Appeal Decision

Appeal Ref: APP/R5510/D/23/3315807

2 Halford Road, Hillingdon, Ickenham UB10 8PY

- The appeal is made under section 78 of the Town and Country Planning Act 1990 against a refusal to grant planning permission.
 - The appeal is made by Mr Mark McLachlan against the decision of the London Borough of Hillingdon.
 - The application Ref 56582/APP/2022/3337 dated 1 November 2022, was refused by notice dated 23 December 2022.
 - The development proposed is for the raising of roof to provide habitable accommodation within loft space, to include a double hip to gable conversion, roof lights, front and rear dormers, and erection of a two-storey side/rear extension, rear patio and external alterations to property.
-

Section A - A

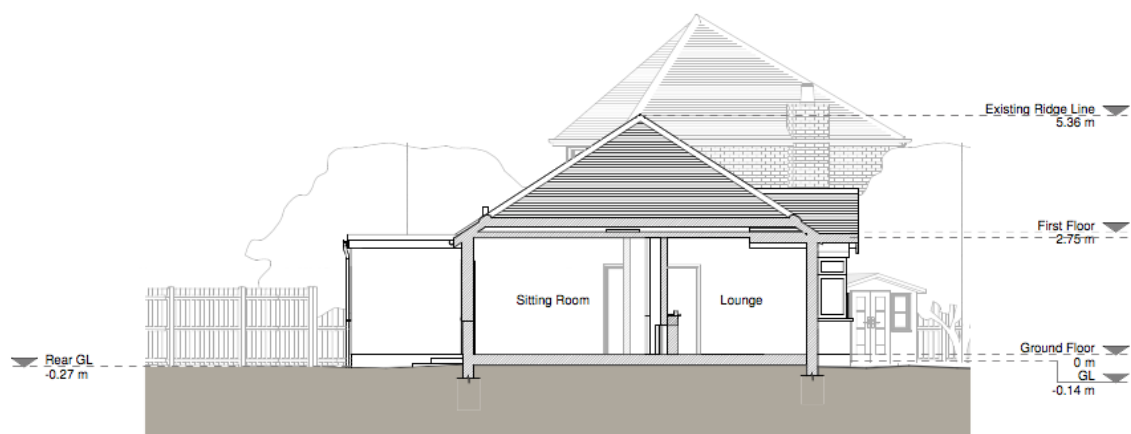
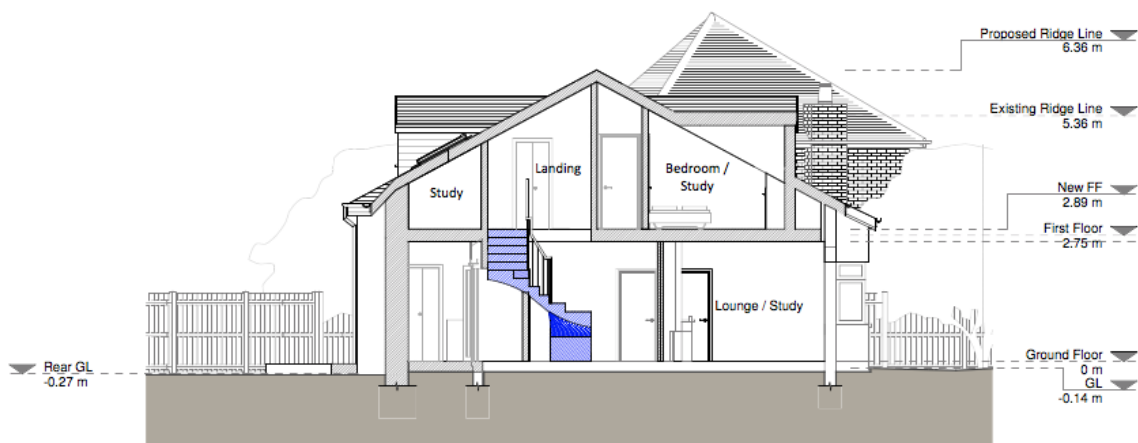
7. Due to its corner location and plot alignment, separation to No.4 is already restricted. The resultant property would be slightly offset from the shared boundary, but there would be a limited visual gap between the two properties, which would have similar depths, and the proximity would be accentuated by the new roof profile.

12. I acknowledge that a level of mutual overlooking is often found in residential areas. This proposal, however, introduces first-floor windows to an existing bungalow and the property has a small rear garden. The distance to the boundary with No.4 is limited and that property also has a relatively small area

of amenity space to the rear. Whilst the development would comply with the 45-degree line in relation to the outlook from No.4 this does not imply compliance with all aspects of amenity. The proposed dormer window would enable opportunities to directly overlook the rear garden to No.4 from an elevated position in close proximity which would result in a harmful loss of privacy to the occupiers. Accordingly, there would be conflict with policies DMHD 1 and DMHB 11 of the Hillingdon Local Plan: Part Two - Development Management Policies (2020) which amongst other things, seeks to ensure that a satisfactory relationship with adjacent properties is achieved.
